**RE: STATE SIGNIFICANT DEVELOPMENT – MONTEFIORE SENIORS
HOUSING DEVELOPMENT - PPTIES: 19-25 COLLEGE CRESCENT AND 9-15
LINK ROAD, ST IVES – SSD 98363228**

I refer to the abovementioned current State Significant Development Application, SSD – 98363228 (SSD Application).

03 - STREET ELEVATION - EAST

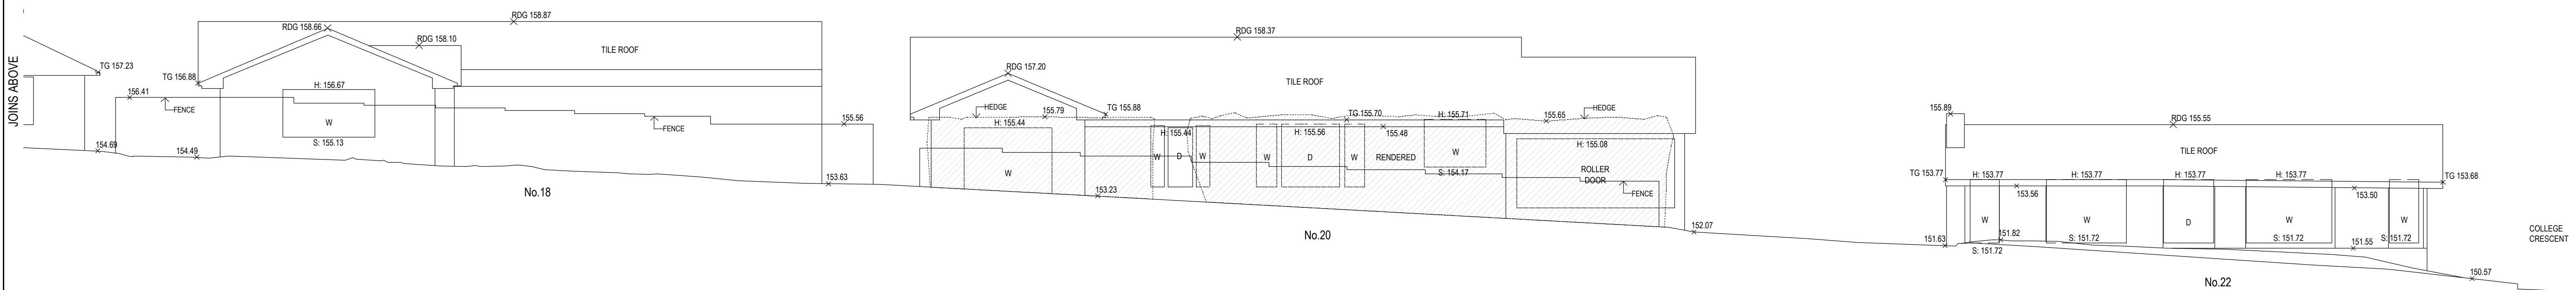
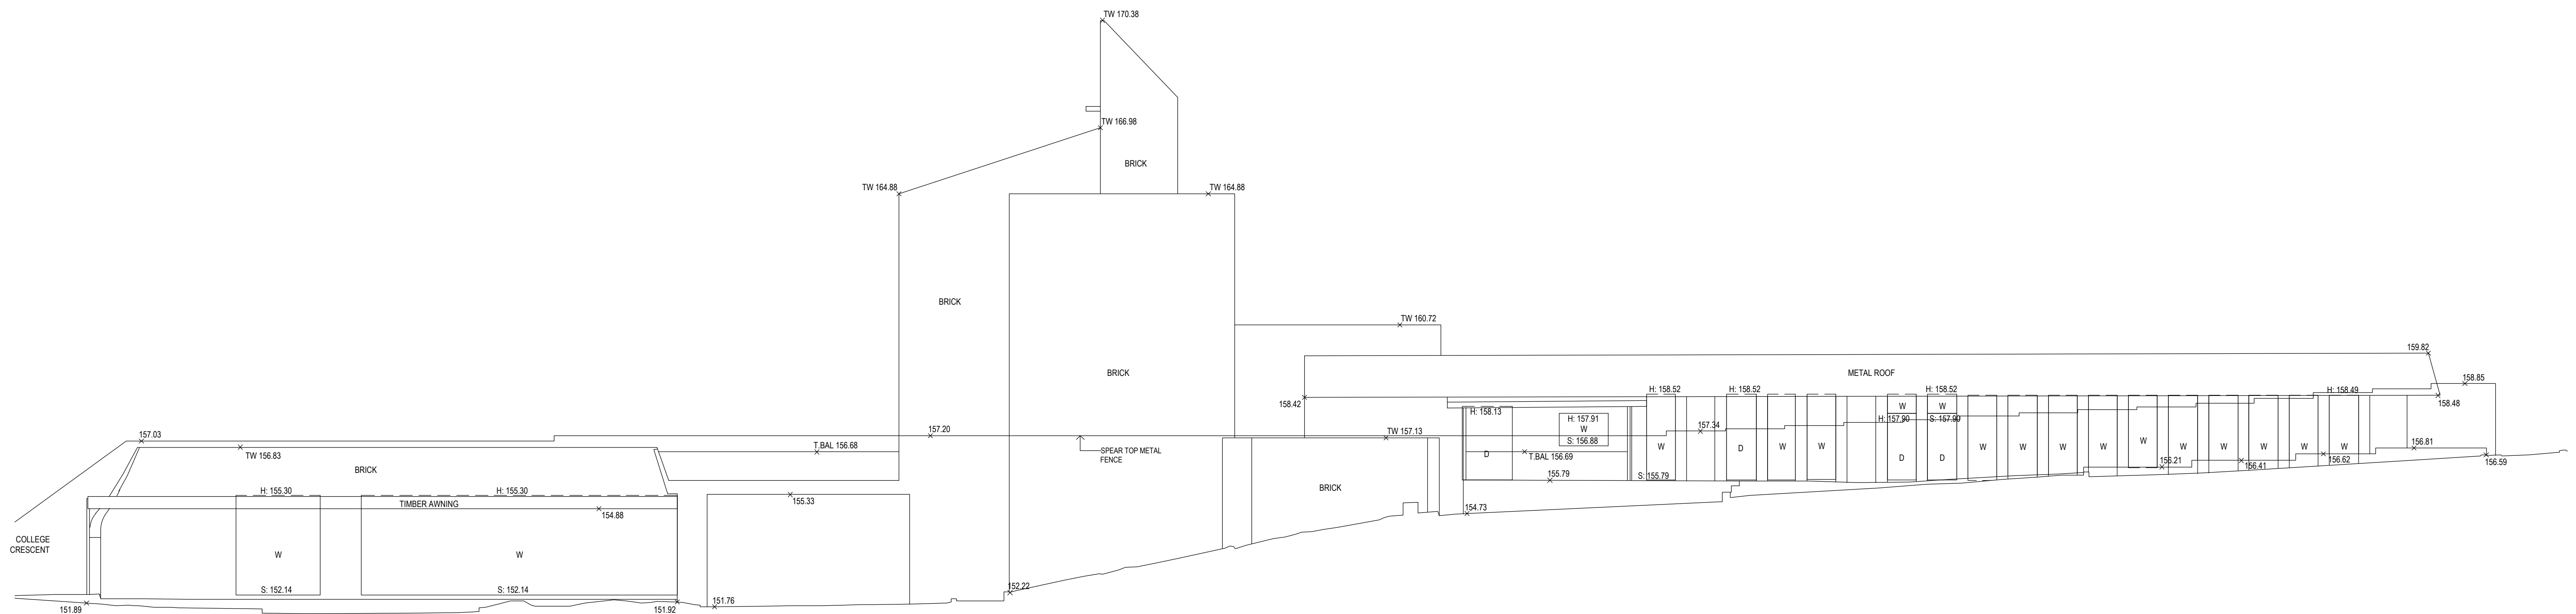
- I particularly raise strong objection to the proposed 4-5 storey façades of proposed Buildings B and C facing College Crescent for the following reasons: -

- i. As previously advised, to the east of the subject site on the opposite side of College Crescent is a Low Density Residential zone fronting College Crescent which comprises 1-2 storey dwellings, with a maximum additional possible 3rd storey up to a height of 9.5m. I consider that the proposed 4-5 storey eastern façades of proposed

Buildings B and C are totally incompatible with the immediate Low Density context to the east.

- iv. Proposed Buildings B and C also sit much higher than the adjoining 1-2 storey dwellings to the east fronting College Crescent. In other words, a person in the College Crescent dwellings will view proposed Buildings B and C as taller than 4 to 5 storeys due to the fact that Buildings B and C sit on higher ground than the road and the dwellings fronting College Crescent.

- v. Thus, I strongly recommend that the proposed eastern facades of Building B and C must be modified to be a maximum 3 storeys in height, with the possibility of a 4th stepped storey setback within the western portion of proposed Buildings B and C, provided the stepped 4th storey is **not** visible when viewed from the dwellings fronting College Crescent. Sight Line Diagrams will need to be prepared to demonstrate that the proposed stepped 4th storey is not visible from the College Crescent dwellings.
